APPLICATION BY SEGRO PROPERTIES LIMITED FOR THE EAST MIDLANDS GATEWAY PHASE 2 AND HIGHWAY ORDER 202X

RESPONSES TO ExQ1

EAST MIDLAND INTERNATIONAL AIRPORT LIMITED (EMA)

FIGURE 3

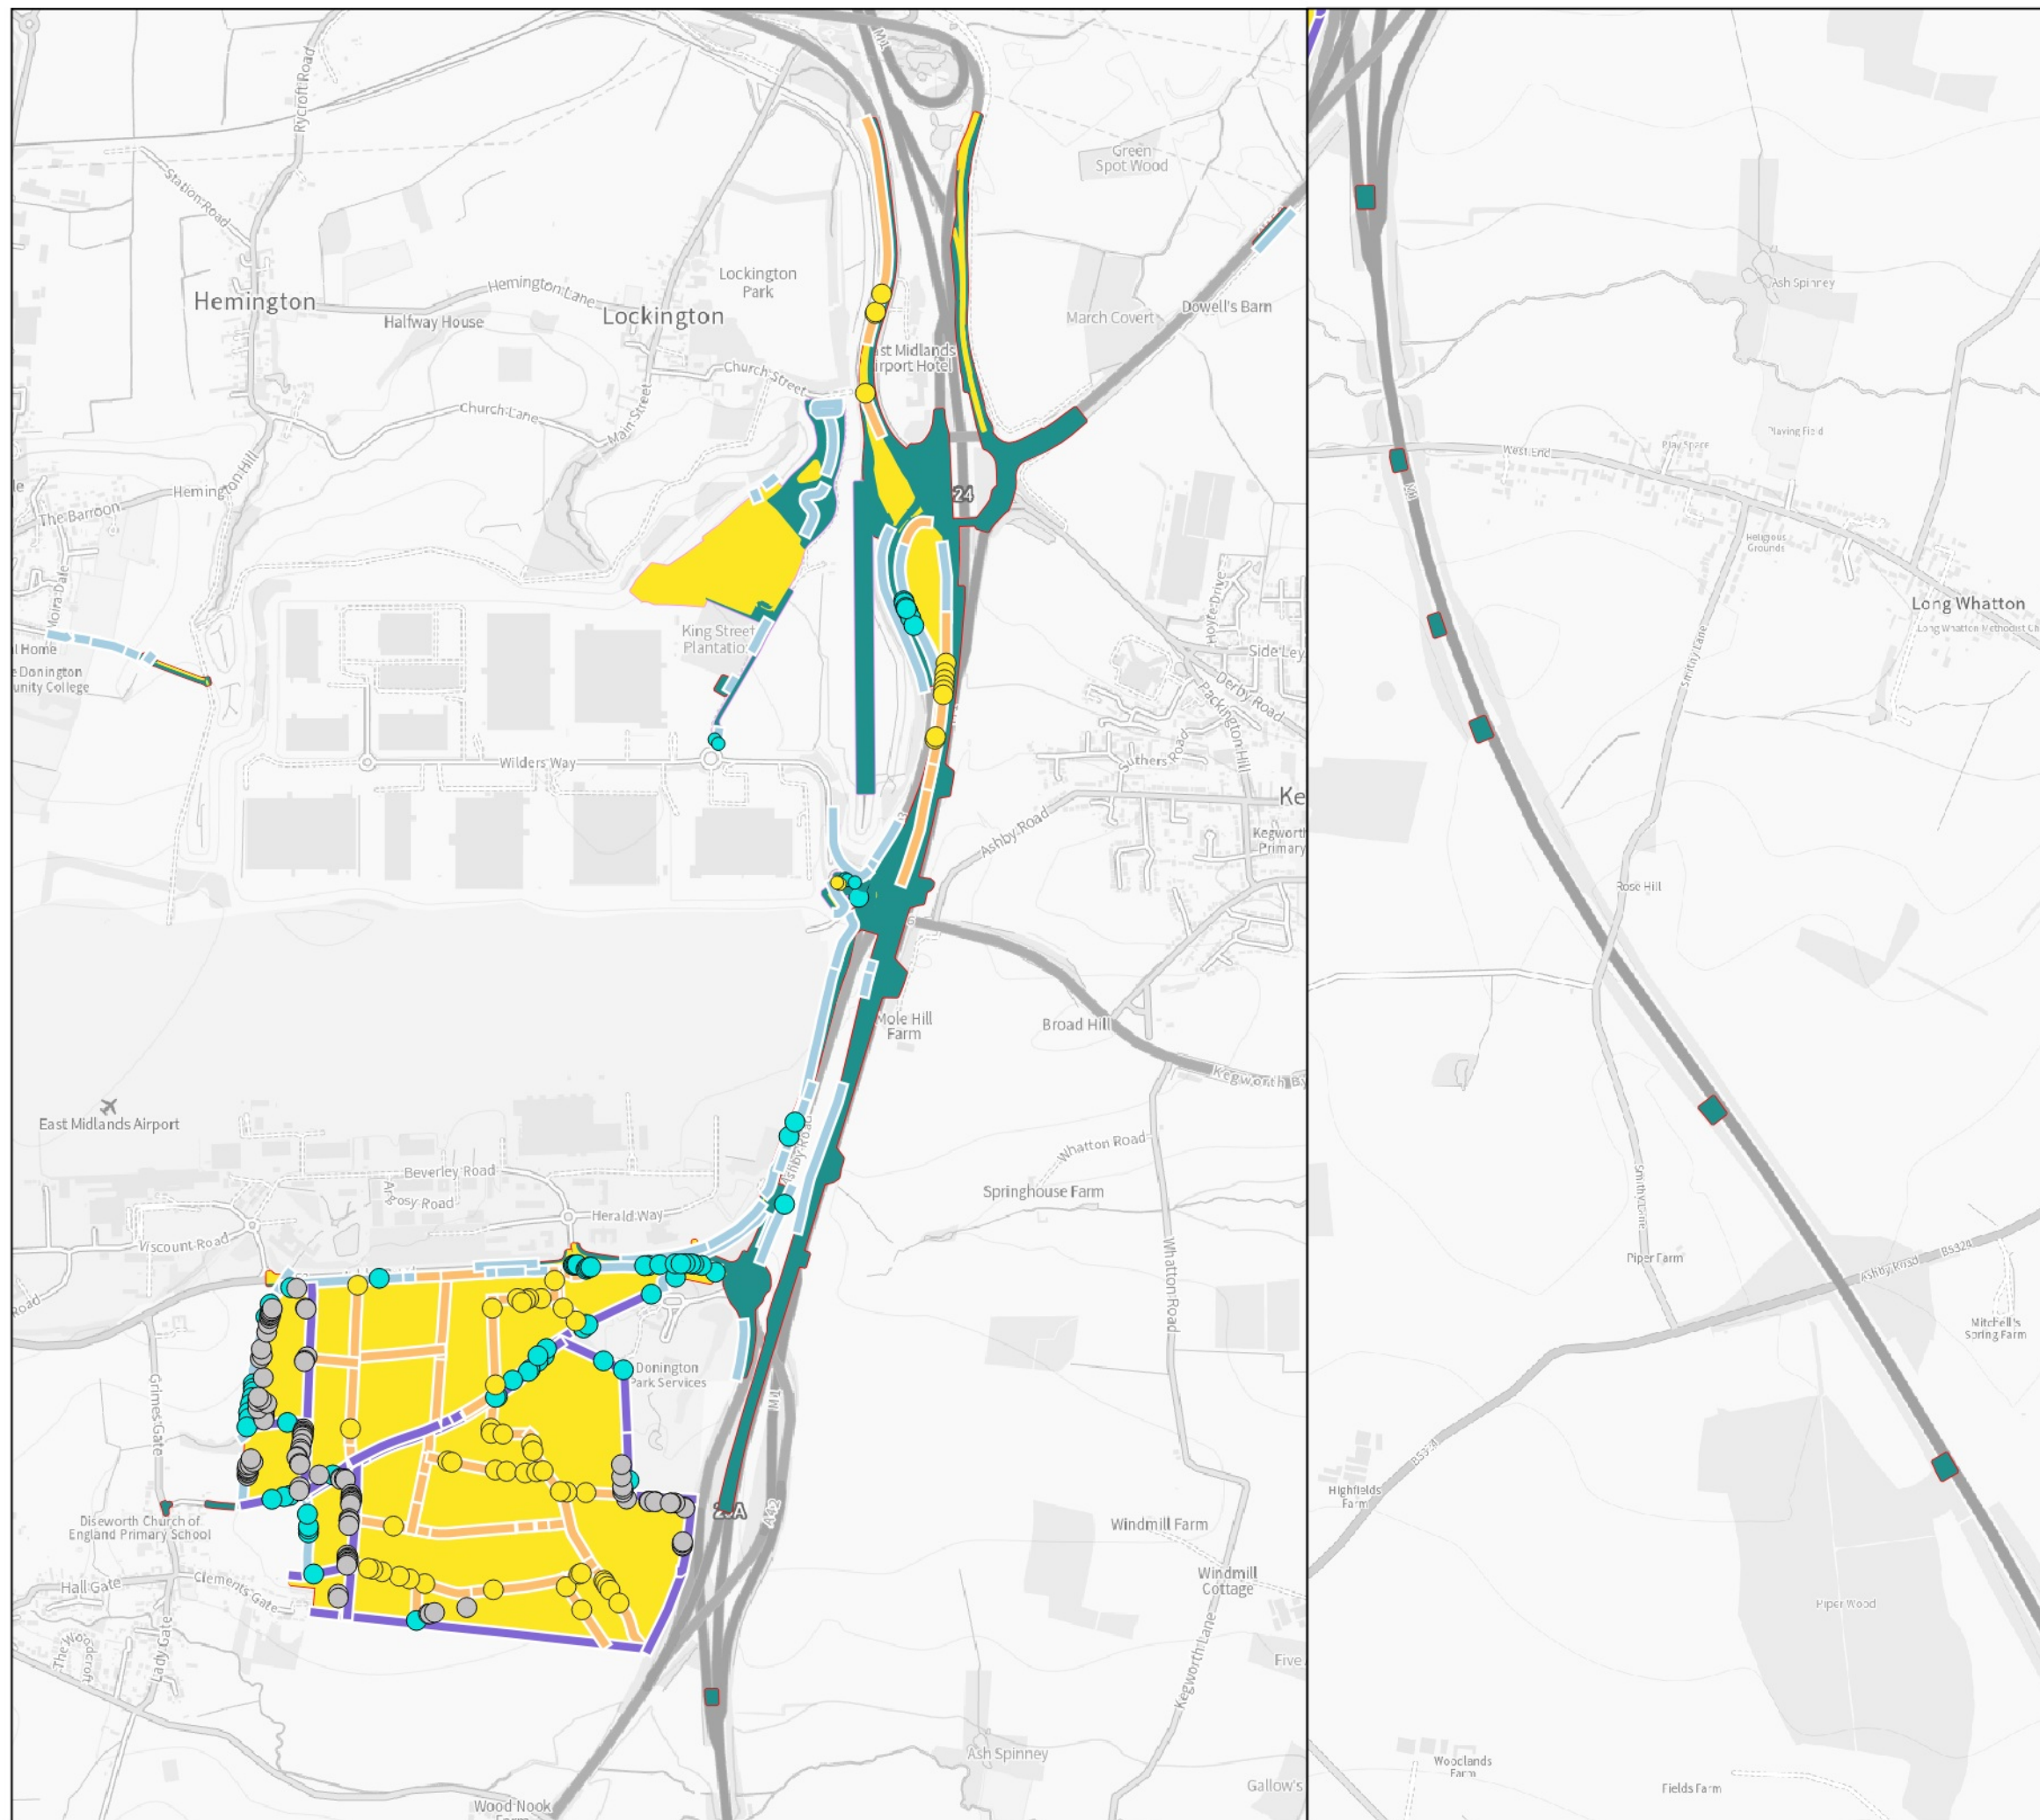
Q5.0.16	The applicants	<p>Works no. 10 hedgerow loss Figure 3 of the BNG Report [APP-116] shows what looks to be a significant length of hedgerow loss associated with Works No. 10 (A50 westbound merge). Can the applicants please explain the importance of this length of hedgerow for protected species, including as a foraging or commuting route for bats present in the area? If it is important, please can the applicants provide more detail on how its loss would be mitigated?</p>	<p>There is a need to consider the displacement of wildlife should any hedgerow be lost and any new hedgerow planting will need to be species specific to avoid the new hedgerow providing a food source for birds that are a hazard to aircraft.</p> <p>EMA is in discussion with the Applicant over ecological mitigation and its impact on aerodrome safeguarding.</p> <p>Protective Provisions are being drafted and discussed with the Applicant to ensure the development is acceptable from an aerodrome safeguarding perspective.</p>

Plan to illustrate the Existing Route of the Airport Trail and the Proposed Route of the Active Travel Link (Work No 14)

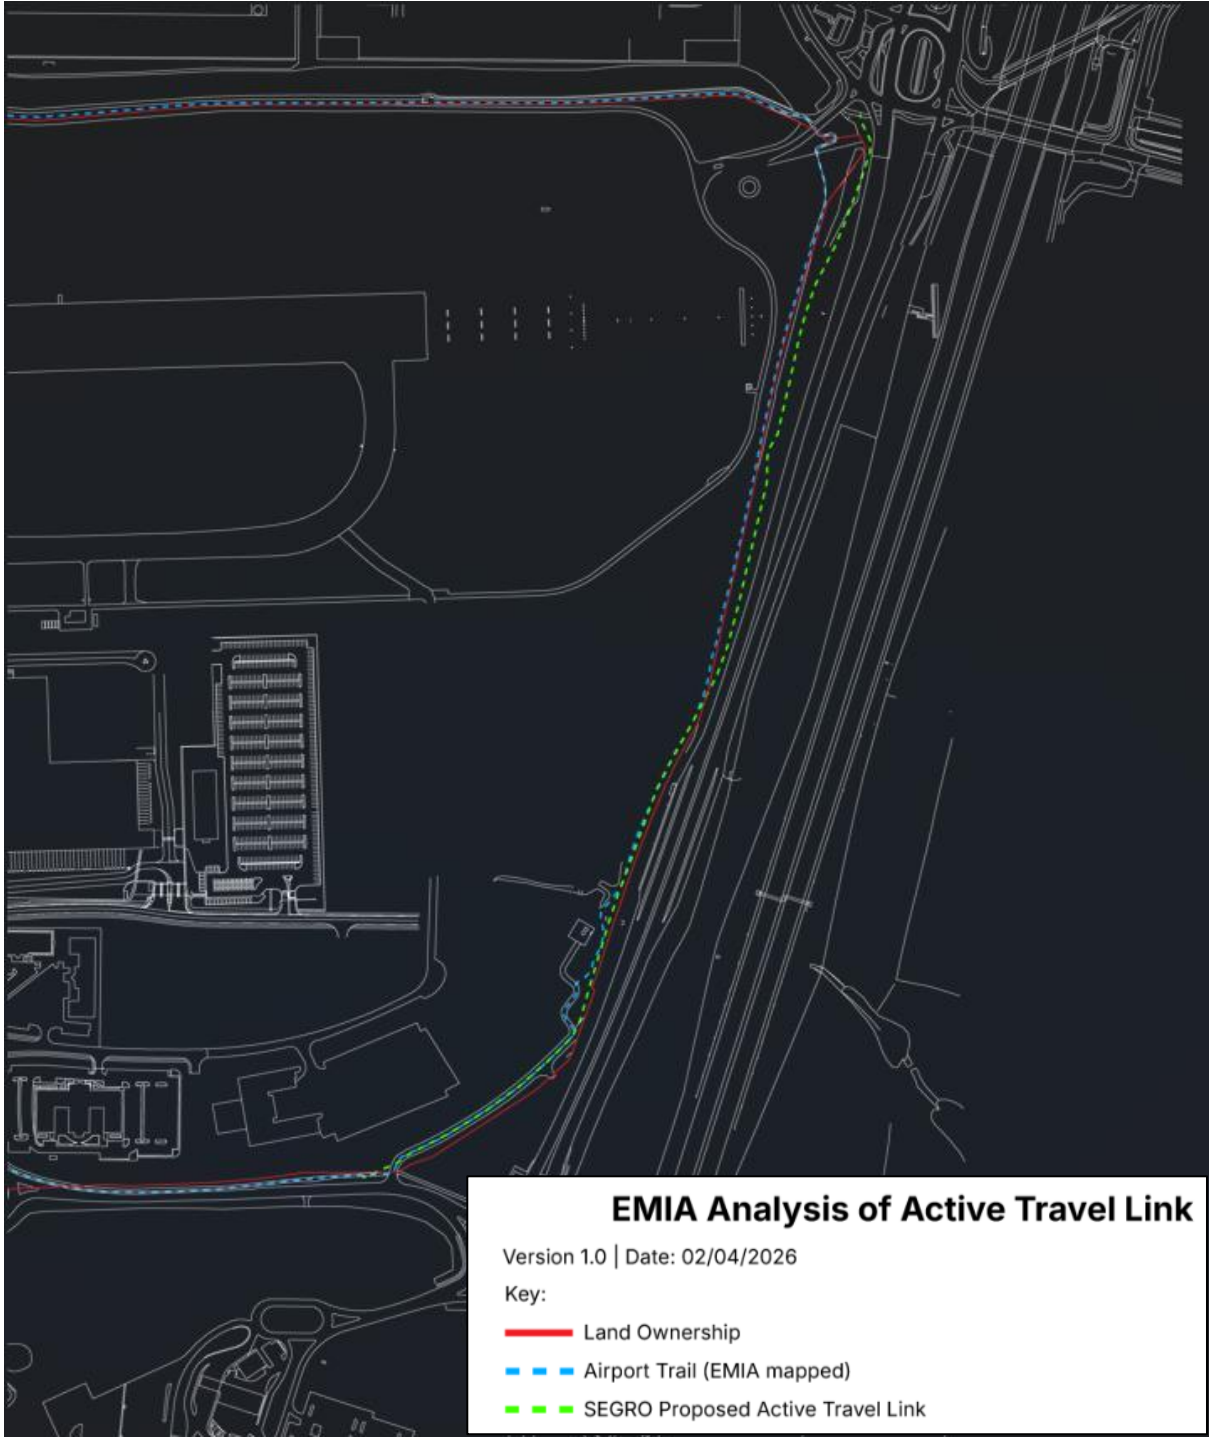
Q7.0.3	The applicants	<p>Plot 2/6</p> <p>Could the applicants explain why they would need to CA the land on the Active Travel Link (Work No. 14, Plot 2/6) rather than just seeking rights to permit the delivery of the route?</p>	<p>The route of the proposed Active Travel Link broadly follows part of the existing EMA Airport Trail, which is a permissive route for pedestrians only. Appendix 1 to our Written Representation illustrates the existing route of the Airport Trail and that proposed through the ATL.</p>

<p>EMA is not satisfied that there is a need for the Active Travel Link.</p> <p>The applicants are proposing a 2% active travel mode share target (Paragraph 9.5, Sustainable Transport Strategy (DCO 6.6B)).</p> <p>Table 9-1 in DCO 6.6B shows that the number of employees on site at EMG2 would range from 600 in year 1 to 2220 in year 5 and thereafter. The active travel mode share target therefore ranges from 12 trips daily in year 1 to 44 trips in year 5.</p> <p>Logically, it must be right that not all of that 2% would use the Active Travel Link.</p> <p>Further, it seems unrealistic to expect workers to cycle along an unlit track in the hours of darkness, especially in winter months when the surface would not be gritted during freezing spells. It will be an unattractive route at those times for those reasons. It is also unclear how easy it will be for cyclists to access the northern end of the Active Travel Link from the wider network to Kegworth and Castle Donington. The applicants have not explained whether the need for Work No 14 is reduced or removed if their proposed cycle link to Castle Donington is not consented.</p> <p>EMA is therefore not convinced how the Active Travel Link could be used by users of EMG1 to reach EMG2 in a safe and efficient manner. Even if users of the Active Travel Link did seek to move between EMG1 and EMG2 in the manner which the Applicant expects, it is not clear how many users would choose this route over and above the bus service that the Applicant is placing great weight upon as part of its overall benefits</p>

<p>package to justify the need for compulsory acquisition powers.</p> <p>Accordingly, in EMA's view the need for compulsory acquisition of this plot has not been established by the Applicant, as the benefit to be achieved by the Active Travel Link does not outweigh the interference with EMA's property rights.</p> <p>Even if a need for the Active Travel Link can be proven, EMA does not accept that the Applicants need to CA the land rather than seeking rights to permit the delivery of the route. This is an alternative that has not been properly explored and which further undermines the case for compulsory acquisition.</p> <p>Without prejudice to its position on the question of need for Work No 14, EMA is in dialogue with the Applicant about ways in which the Active Travel Link could be delivered without the need for the Applicant to own the freehold of Plot 2/6.</p>
Q7.0.7	The applicants Prologis EMIA	<p>Land north of Hyams Lane</p> <p>Could the applicants, Prologis and EMIA set out their understanding as to how the land north of Hyams Lane was sold by the previous owners. That is, was it offered for private sale, by tender, by 'best and final offers' or any other process such as the parties direct approach to the owner? The ExP would appreciate information as to whether the marketing, if any, related to potential options agreements or only for outright sale. The ExP would also appreciate the parties understandings of the timeframes for any such sale. The parties should also submit any documents they may have to support their positions.</p>	<p>EMA owns a large proportion of the land to the north of Hyam's Lane and to the east of Grimes Gate. The land immediately to the north of the Moto Donington Park Services was acquired in the 1990's by National Express, the former owner of the airport, this land was included in the acquisition of East Midlands Airport by MAG in 2001. The remainder of the EMA land was acquired in 2010 as part of the auction sale of the agricultural Langley Estate (elements of Old Hall and Cross Farm). As the sale was facilitated by auction, this was an outright sale with no ability to take an option agreement from the seller. It is unknown whether SEGRO participated in the auction process at the time.</p>
